COMMUNITY DEVELOPMENT DEPARTMENT
501 Delta Avenue ♦ Marysville, WA 98270 ♦ (360) 363-8000

Re: PA23-018 – Pilchuck Rentals CUP – Technical Review 1

RE: Pilchuck Rentals, File# PA23-018
New Commercial Building and Distribution
3304 156th Street NE & Parcel #31053200102800

1 NORTH ELEVATION
SCALE: 1/8" = 1'-0"

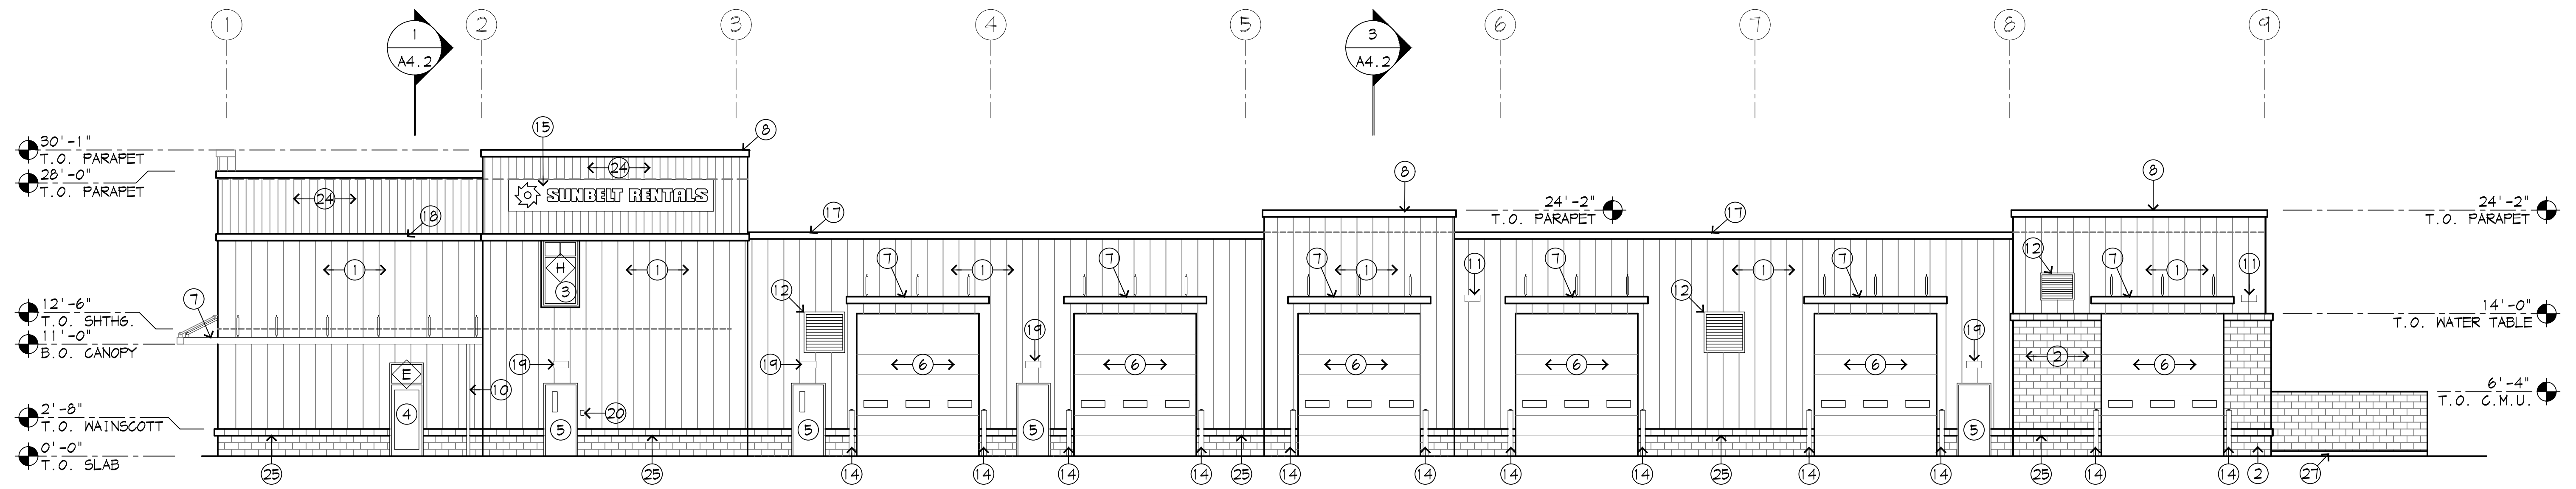
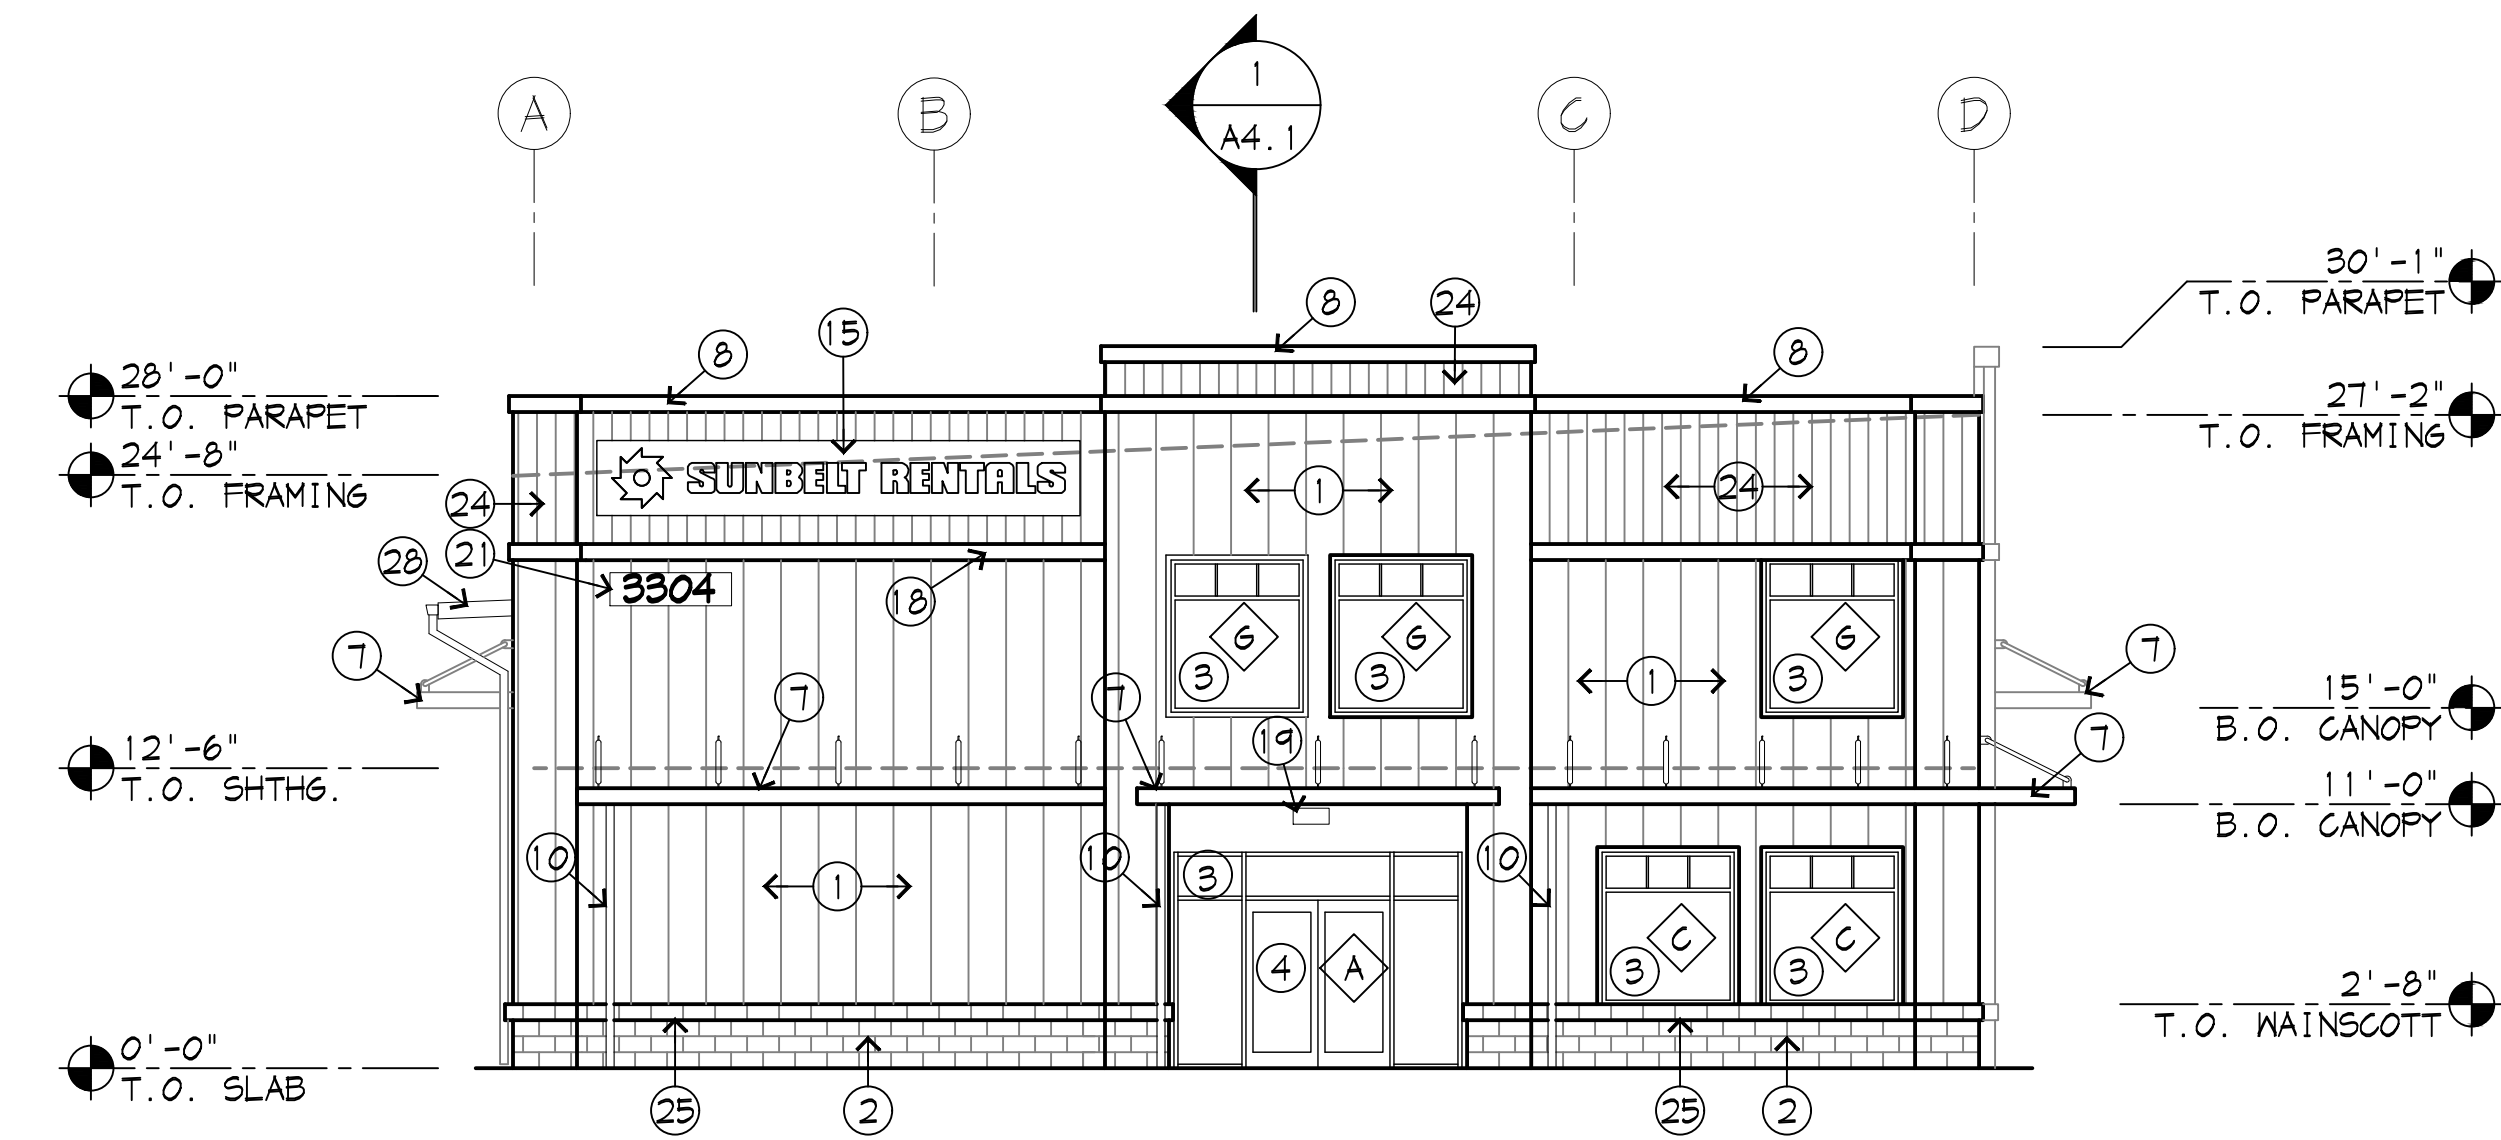
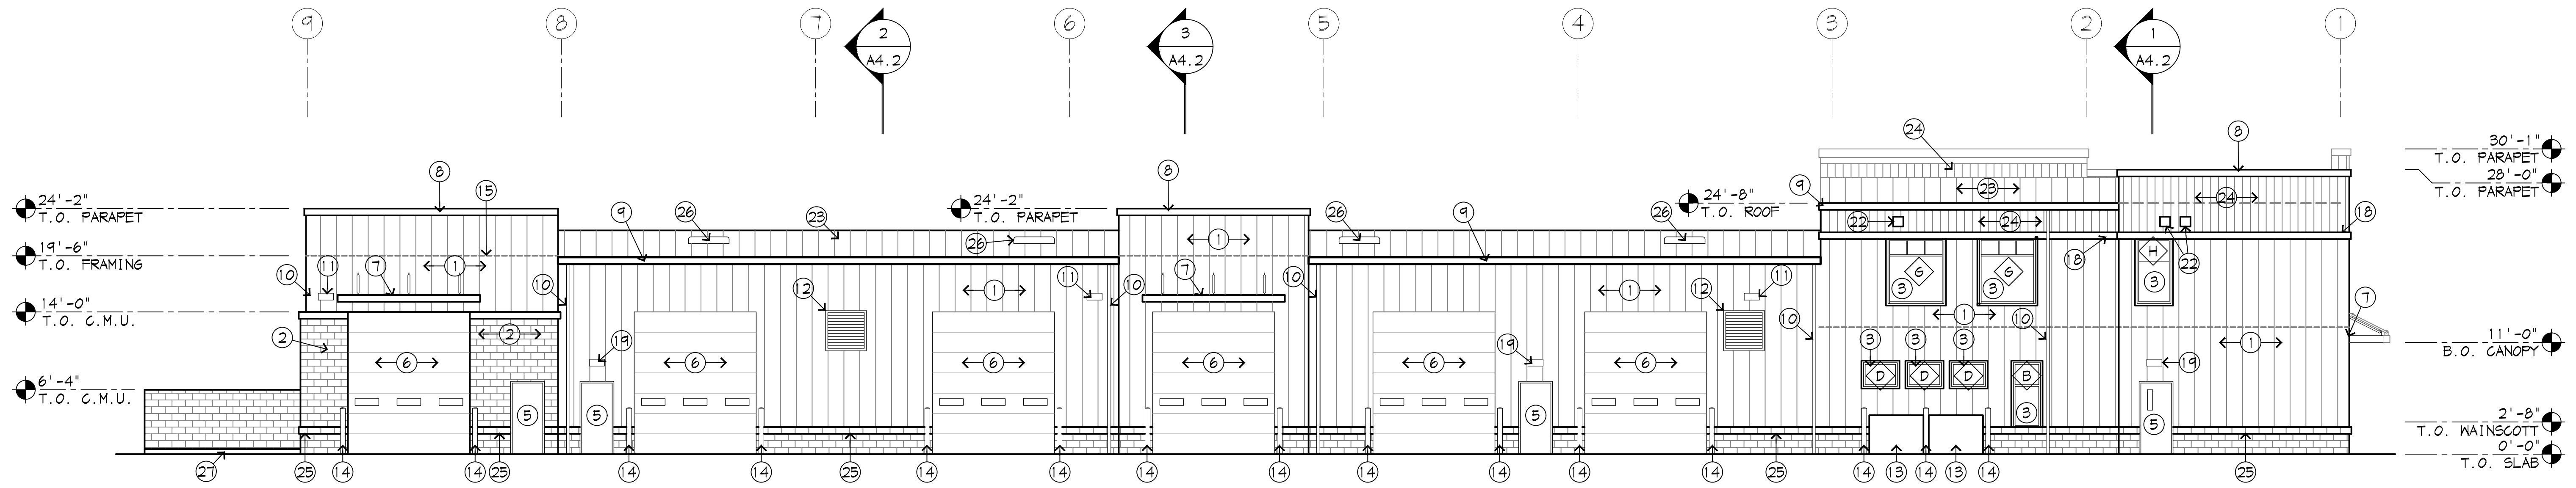
MMC 22C.020.250(7)(a) – Façade modulation. It does not appear that any façade modulation is proposed. Please revise to meet the façade modulation requirements in this section.

MMC 22C.020.250(7)(b) requires street front articulation. Please include at least two of the options listed in this section.

MMC 22C.020.250(7)(d) – Roofline Modulation. It does not appear that there is sufficient roofline modulation to meet these standards. Please revise accordingly.

MMC 22C.020.250(9)(a)-(c) – Building Design details. Additional elements are needed to meet these standards. This could include, but is not limited to, extending the brick shown along the lower portion of the building and wrapping it around all elevations, varying the color/material to provide some actual interest, and incorporation of more varied high quality materials.

MMC 22C.020.250(10) – Building Materials. Metal siding must have visible corner moldings and trim...and incorporate masonry stone, or other durable permanent materials within two feet of ground level. This is required on all frontages visible from public streets (north, west, and east). Metal siding must also incorporate multiple colors.

MMC 22C.020.250(10)(e) Prohibited materials. Any sheet materials, such as wood or metal siding, with exposed edges or unfinished edges, or made of nondurable materials as determined by the director. Proposed building materials and details list shall be provided for review by the director. As proposed, no treatment of the exposed edges is proposed, this will be required to be revised.

3 WEST ELEVATION
SCALE: 1/8" = 1'-0"

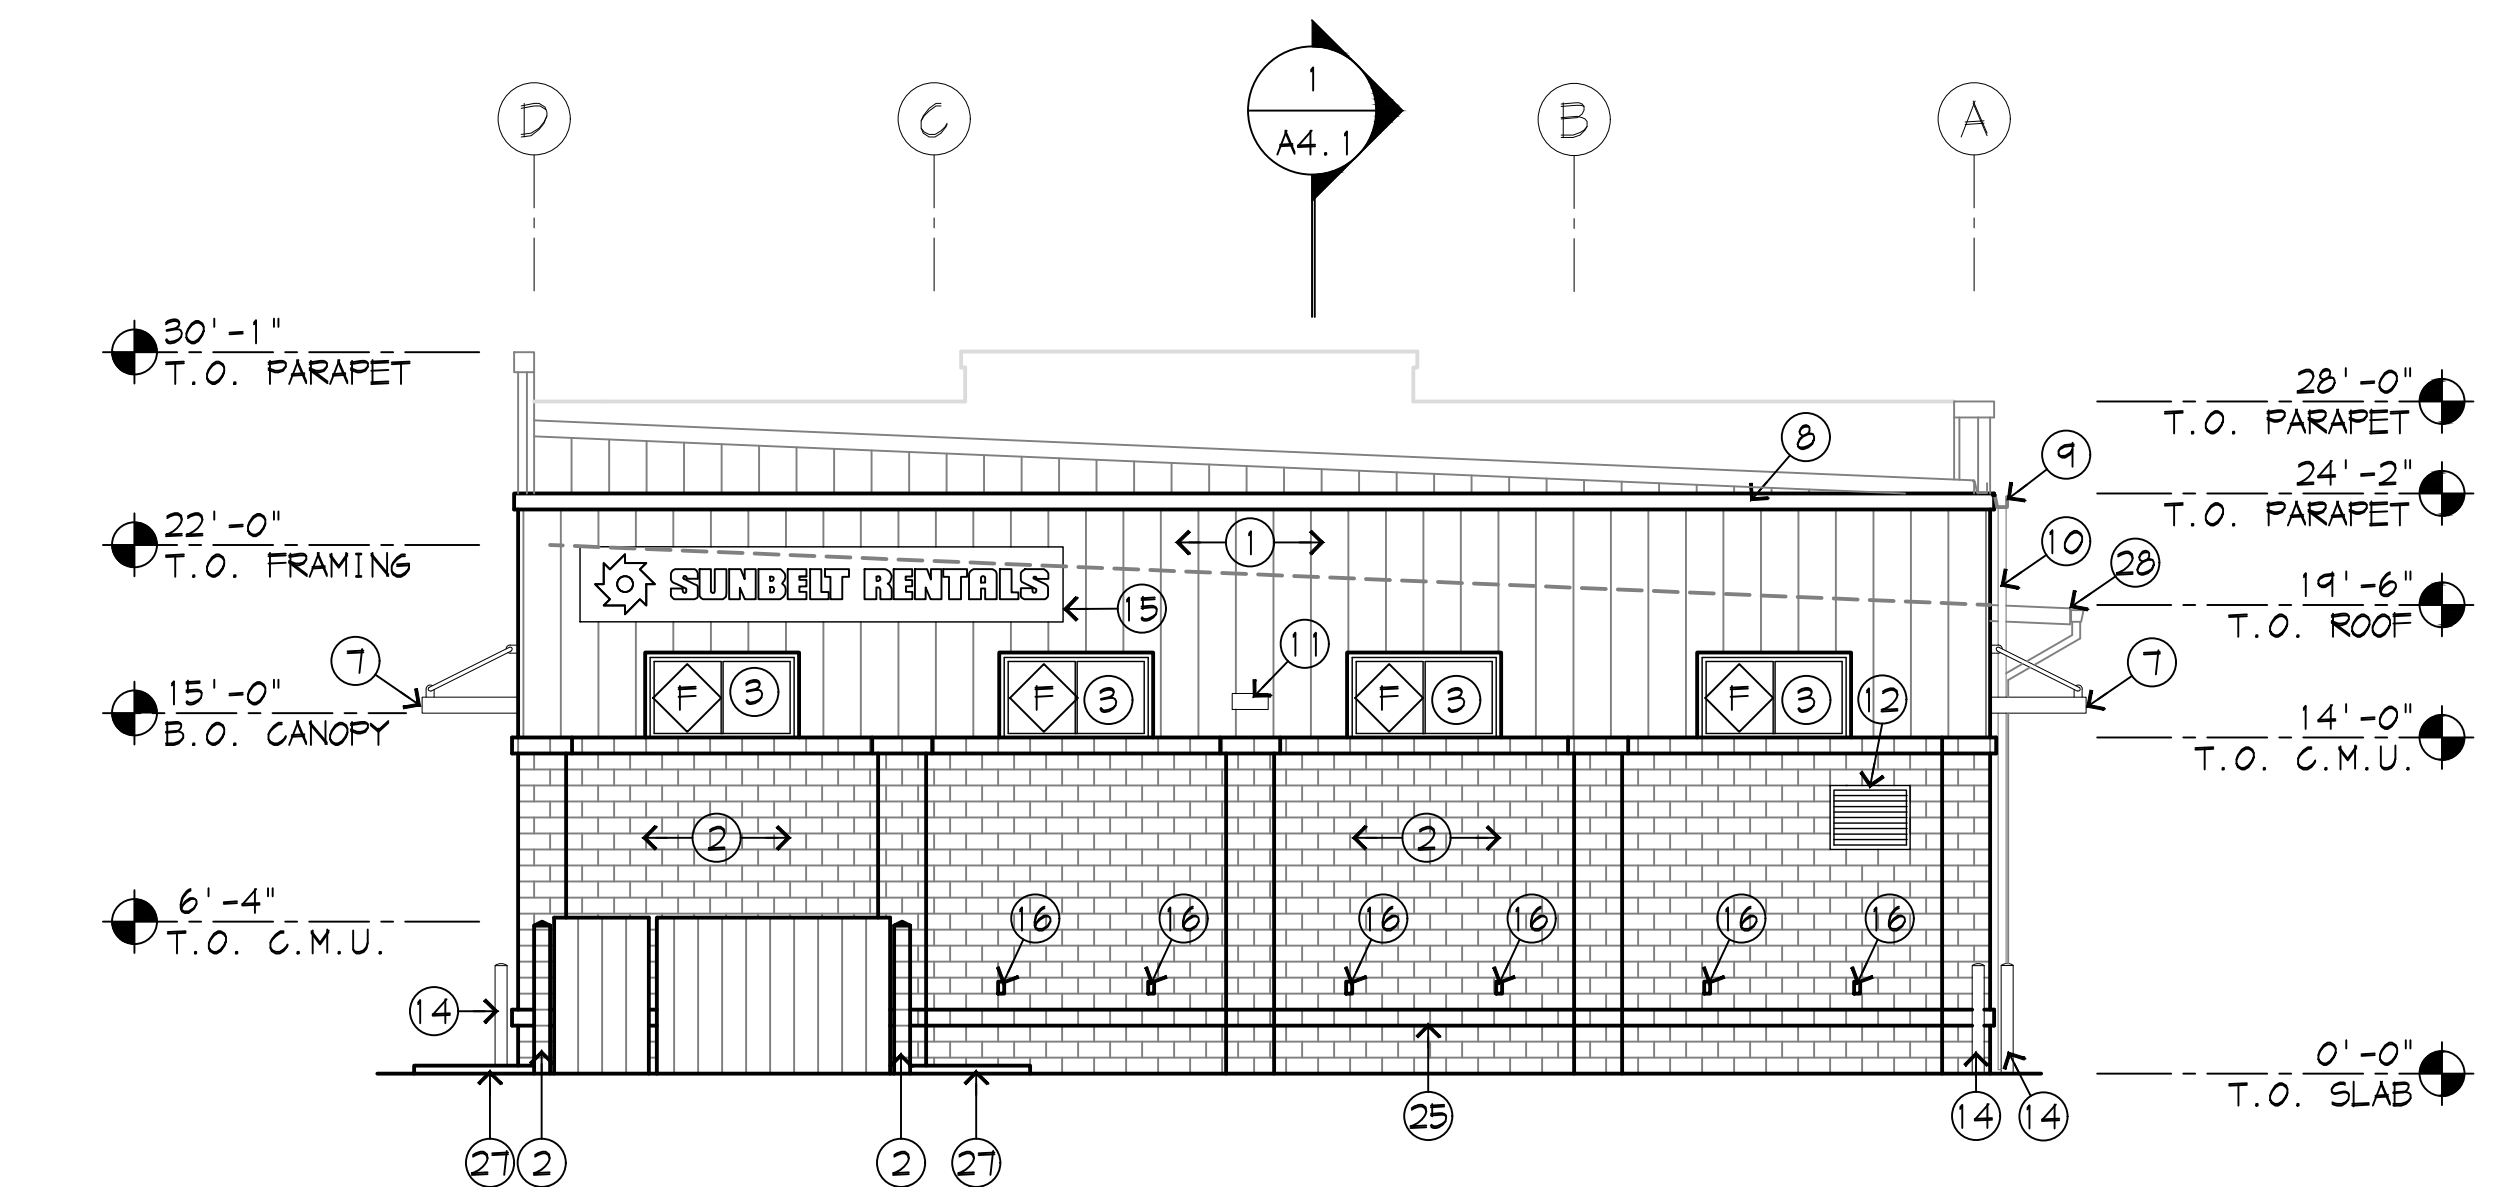
The west elevation meets the definition of a blank wall and is required to include one or more of the treatments outlined in MMC 22C.020.250(11).
